East Anglia ONE North (EA1N)
East Anglia TWO (EA2)
Offshore Wind Farms

Planning Inspectorate References: EN010077 and EA2 : EN010078

Post ISH2 hearing submission including written submission of oral case

Submitted for Deadline 3 (15 December 2020)

# ASI 2 Aldringham Item Nos 4 and 5 Map showing main features

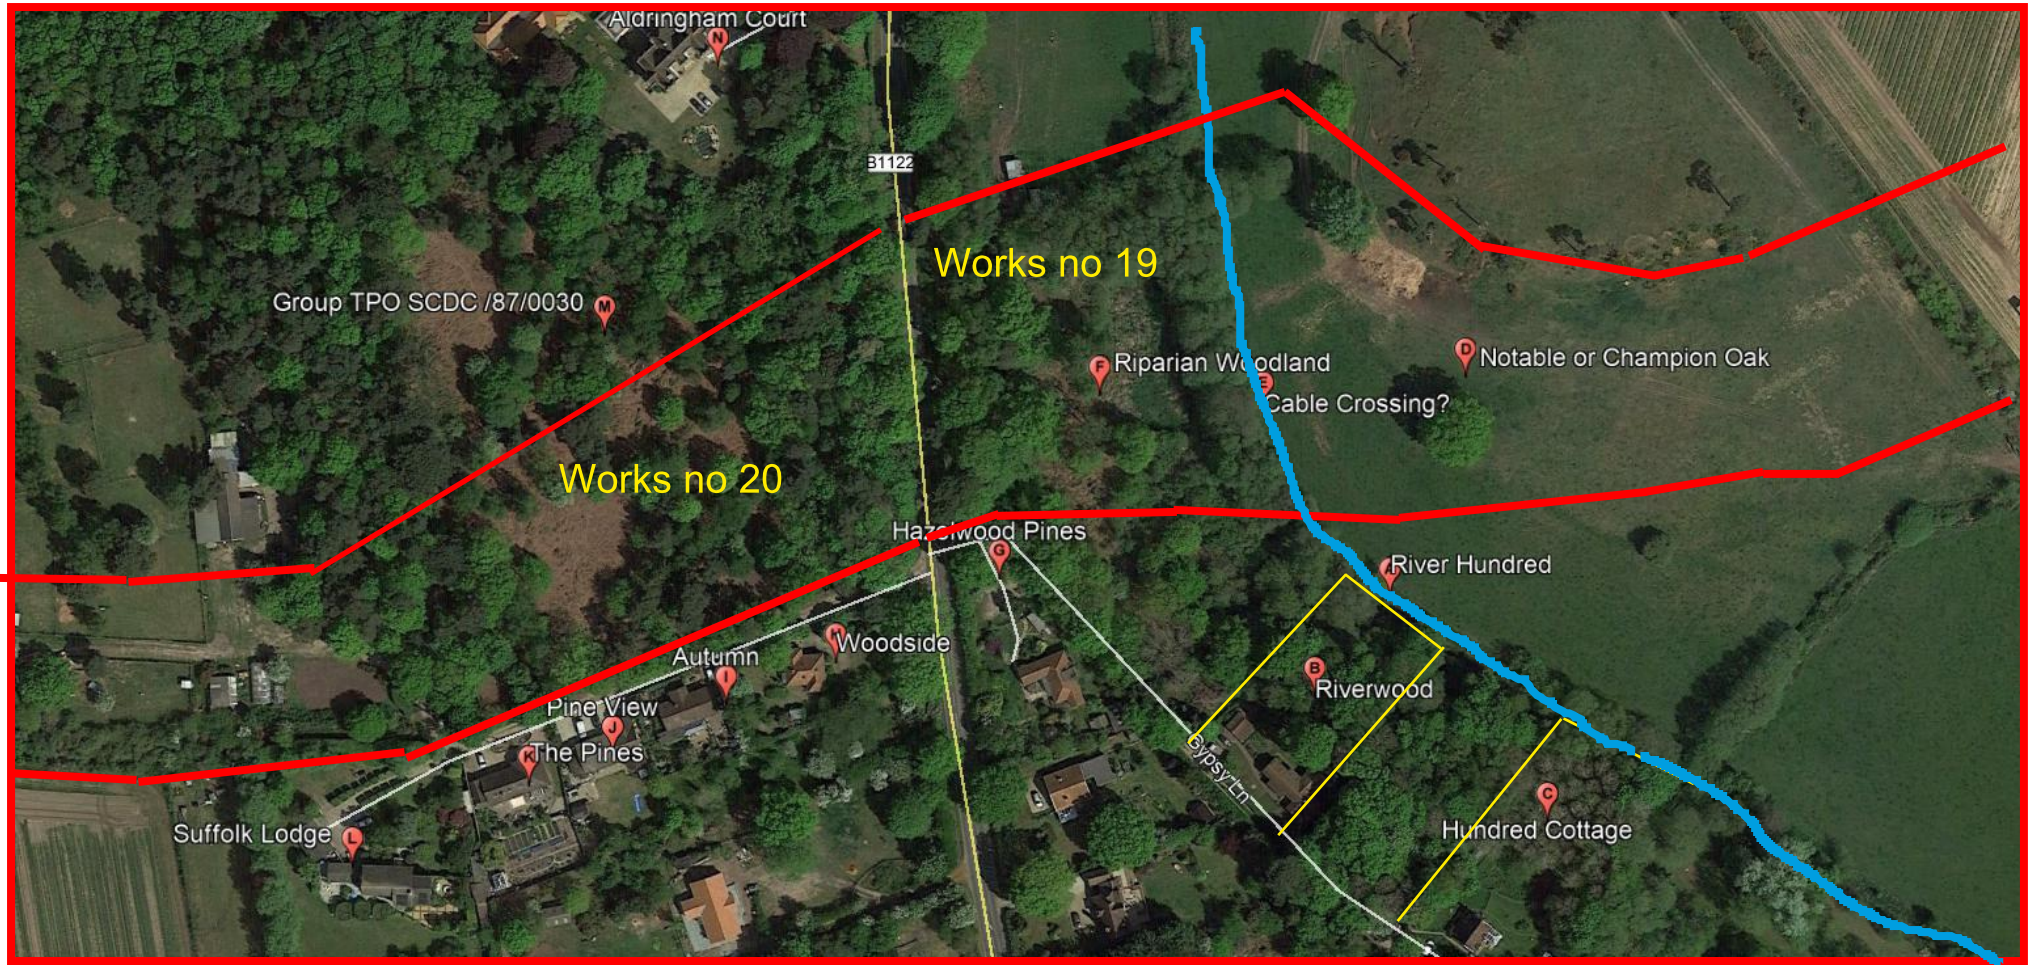
Further, up to c. 0.9 Ha of deciduous woodland adjoining the West carriageway of the Aldeburgh Road would be sacrificed including a Group Tree Preservation Order area that residents had fought to defend over many years.

6. Similarly, the Applications do not recognise the value of up to 0.9 Ha of riparian woodland on the East side of Aldeburgh Road. They do not specify reduced width or replanting of trees there.

8. No evidence has been presented that any other crossing points were ever considered and EIA Site Selection Reports do not consider the feasibility or options for crossing Aldeburgh Road.
No further attempt was made to look at other potential crossing points after SPR had reduced the specification for the cable corridor width at Aldeburgh Road [including haul road(s)] from 50 m to 27.1 or 16.1m.

12. A 92 metres width of land is available within the Order Limits on both sides of B1122 between Fitches Lane and Aldringham Court’s southern land boundary. Even at this late stage, the

Applicants have provided no indication on where the 16/27 metres tranche of cabling would be positioned, except to say that only 5 metres of woodland would be preserved between Fitches Lane Ref 6.1.4 Environmental Statement 4.9.2.2 (171) [APP-052]. Is that a further indication that there is an intention to install EA1N and/or EA2 cable trenches as close as possible to Fitches Lane in order to enable other Applicants including NGV to install their HV cabling at the same pinch point?

15. Mr McGrellis (for the Applicants) confirmed that a reduced 27.1/ 16.1 metres wide cable corridor on both east and west sides of Aldeburgh Road would be all that was needed for agricultural and engineering purposes and would be contained within the two Construction Fences. He stated that the 92 metres order limit width has been specified in order to make provision for the purposes of 'Micrositing' later on. He did not explain the Applicants' reasons for retaining only 5 metres of the 92 metres of woodland available between Fitches Lane and the Cable Corridor. He stated that the Applicants would apply the same 'logic' on both sides of Aldeburgh Road, constraining the cable corridor within a maximum width of 27.1/ 16.1 metres, every effort being taken to preserve trees and hedges.

16. The Applicants intend to replant all trees removed during construction, except for those within tree root distance from cabling where heathland would be established. It was unclear whether that is also the intention on the riparian land on the flood plain to the east of Aldeburgh Road (presumably unsuitable for heathland).
